CITY OF ALBUQUERQUE

Sept. 18, 2018

RE: **Juan Tabo Hills Park**
Grading and Drainage Plan for SPBP – Approved
Engineer's Stamp Date: 9/12/2018 (M22D017A)

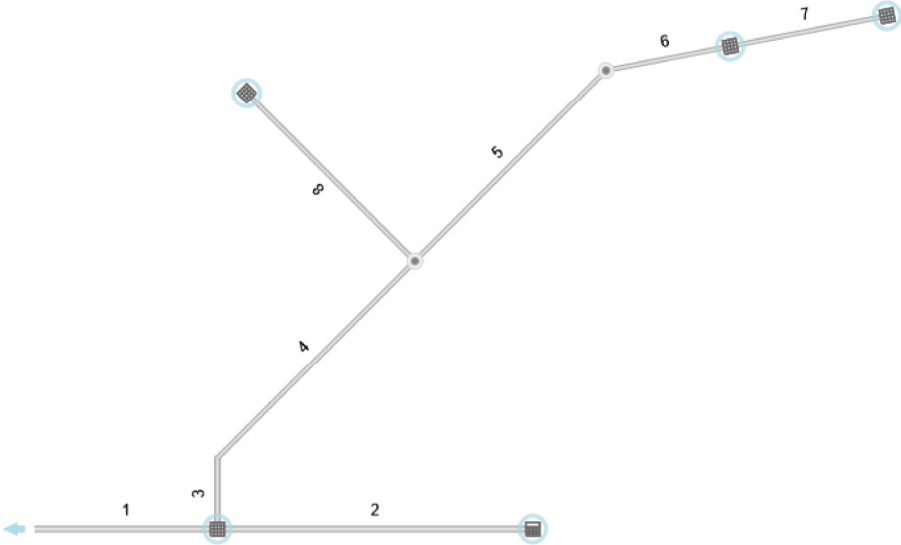
1. Remove the label "Not for Construction" under the engineer's stamp and sign the stamp.
2. Verify the Sidewalk Culver Capacity using the weir equation. Grates are now standardized at 24". Use the appropriate number of grates.
3. Add a construction note on the plan stating that an excavation and barricading permit is required for the New Type D inlet on the existing public storm drain and the Sidewalk Culverts.
4. Verify the Gulfstream Ct. inlet calculations using a weir equation at the lip of gutter, which is 0.75' below the property line elevation.
5. Grant Public Drainage easements on the existing 48"- 66" storm drain on the east side of the site (25' min width centered on the pipe) both north and south of Monachos Rd.
